**Subject: Chuze Fitness Traffic Impact Study
NM 45 (Coors Blvd) and Central Ave
Albuquerque, New Mexico**

This letter is to inform you that the **FINAL** Traffic Impact Study (TIS) for Chuze Fitness dated March 2023, Ver 2 has been reviewed. The proposed development is located in the southwest quadrant of NM 45 and Central Avenue.

FIGURE 2
Albuquerque Chuze Fitness
Site Plan

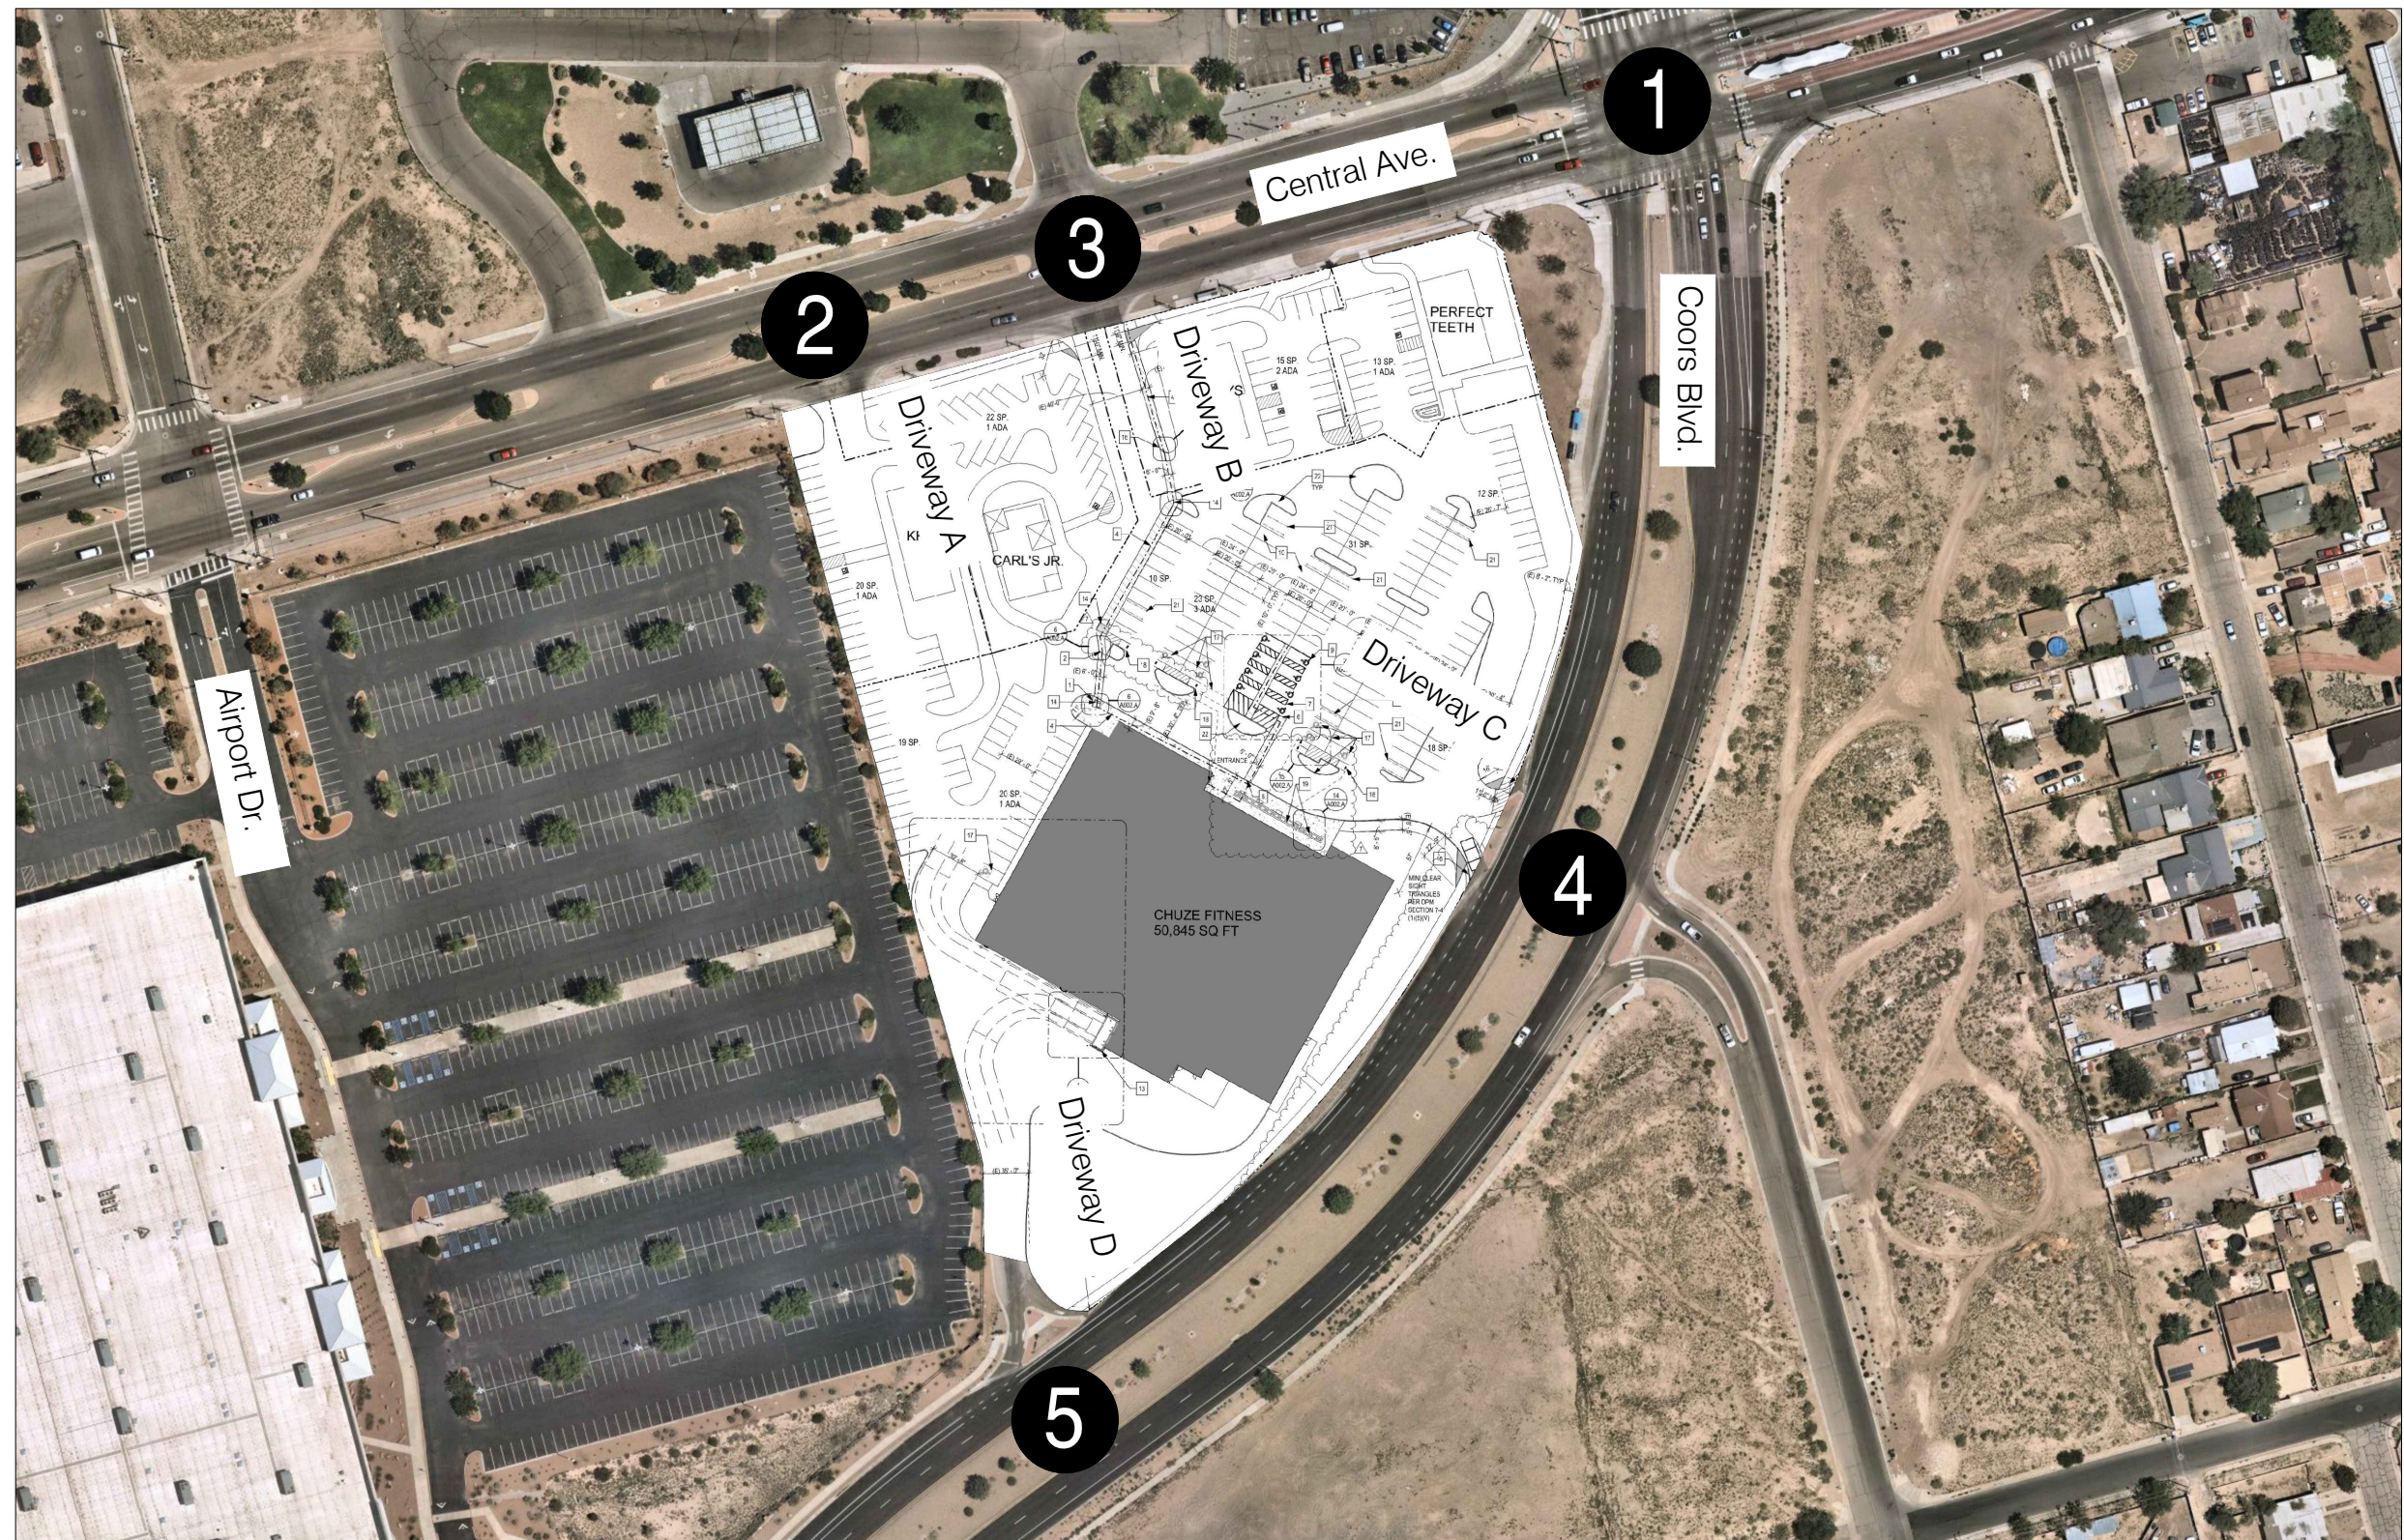
The NMDOT has no objection to the use of two partial access points to Coors Blvd called “Driveway C” and “Driveway D”. See Exhibit A for the site plan for this development. The partial access points will be limited to right-in and right-out access only. The recommendations made for this TIS are shown in Exhibit B attached. Based on these analyses, the following conditions are required:

1. The property owner shall submit a Commercial Driveway Application for two partial access points on NM 45. Both access points are right-in and right-out only.
2. At NM 45 and Central Avenue the development shall lengthen a single NM 45 northbound left lane by 225-feet to meet minimum deceleration lane criteria.
3. The development shall remove the acceleration lane at Driveway “C” on NM 45.
4. The NMDOT shall provide final approval on the design for the offsite improvements. The developer shall agree to incorporate all the comments requested by the NMDOT.
